Further Env Health consultation response
(incl request for acoustic fence condition)

From: Craig Milligan <Craig.Milligan@arun.gov.uk>
Sent: 04 February 2022 11:22
To: Simon Davis <Simon.Davis@arun.gov.uk>
Subject: RE: AL/129/21/OUT

Project: Land Adjacent to Woodgate Nurseries	Title: Site & Survey Location		
DWG No: Figure 1	Scale: N.T.S.	Rev: 0	
Date: September 2021	Drawn By: MH	Job No: 9249-1

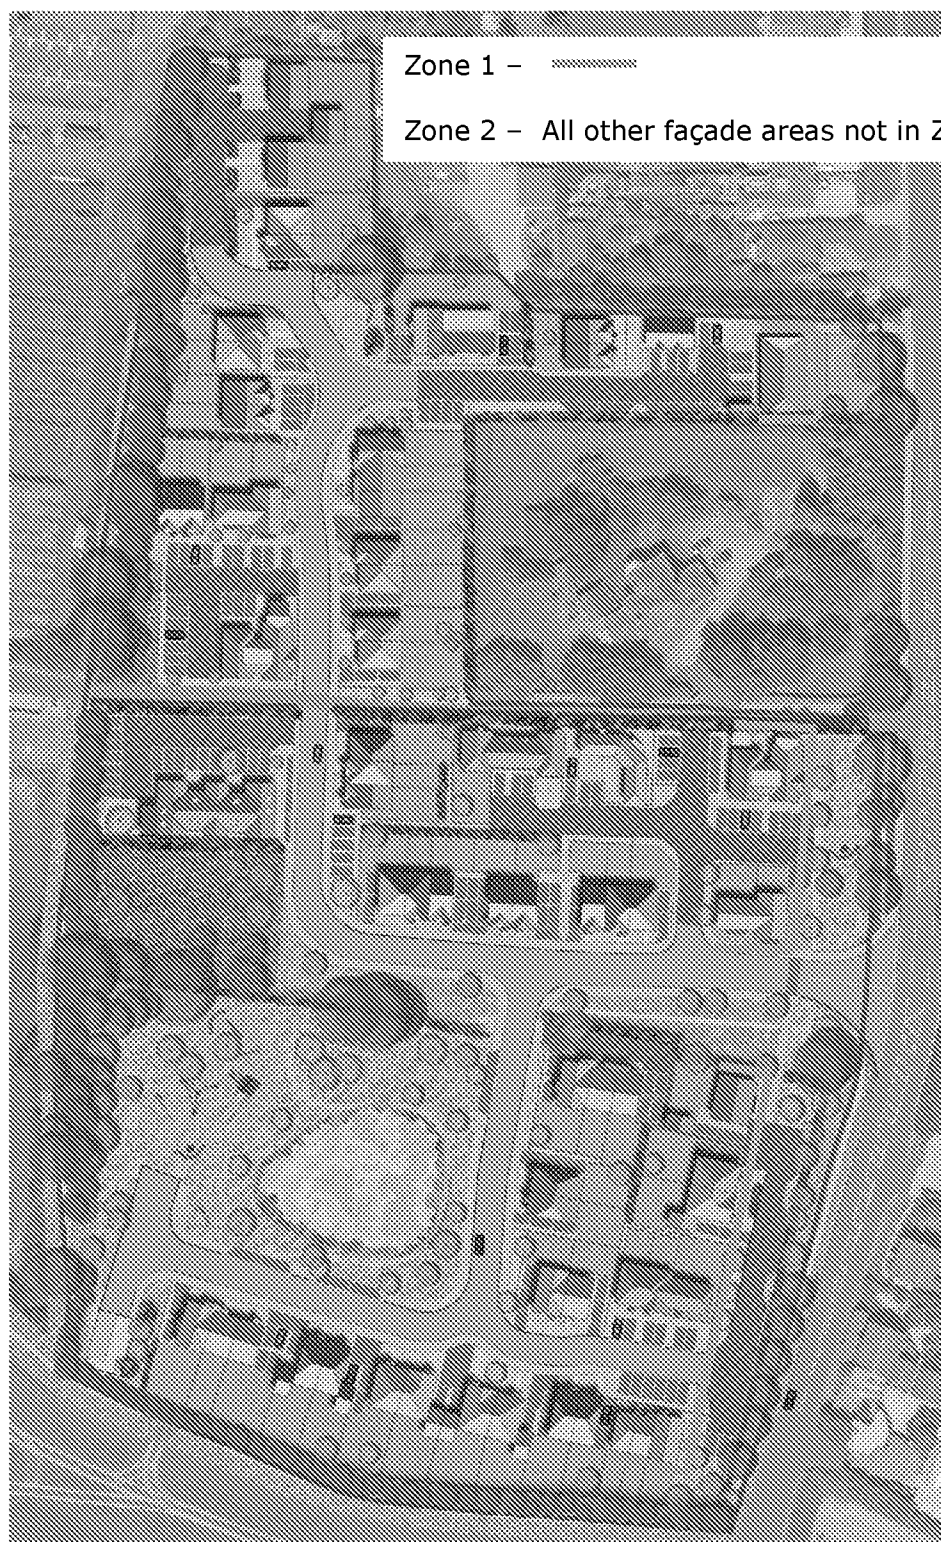
I visited the site on Monday 31st January 2022. I can confirm the loading area and car park is to the North of the site however, an access track/road runs along the North and Western boundary of the proposed development site to access glass house ruins. It is my opinion, that if activities were to resume in Woodgate Nurseries there is potential for detrimental noise impact on external and internal amenities from vehicle movements and commercial activities.

I therefore recommend that a 1.8 meter acoustic fence is installed along the Western Boundary of the development site and the northern boundary of the Northern most plot.

The derelict greenhouses to the west of the site are not considered to be a significant source of noise. Noise monitoring equipment was set-up in the north western corner of the site and following the analysis of this data it was concluded that there was little to no activity coming from the site.

Greenhouse buildings are not considered to be a significant noise source when in use. Should they be re-occupied, we do not believe that the greenhouse buildings would produce a noise level that would impact the proposed properties. As a horticultural use the activities will not be any more problematic than might be found from farming on agricultural land in our view, which are in most cases widely accepted to be insignificant in noise terms.

Based on our experience and historical measurements undertaken near to other nurseries and garden centres, the main sources of noise would be the delivery area and car park. From the site layout of the existing nurseries, the access road and car park are located to the north of the site, at a significant distance from the proposed properties. Noise from the nurseries (should they come back into use again) is therefore not expected to have an adverse impact (never mind a significant one) on the proposed development.
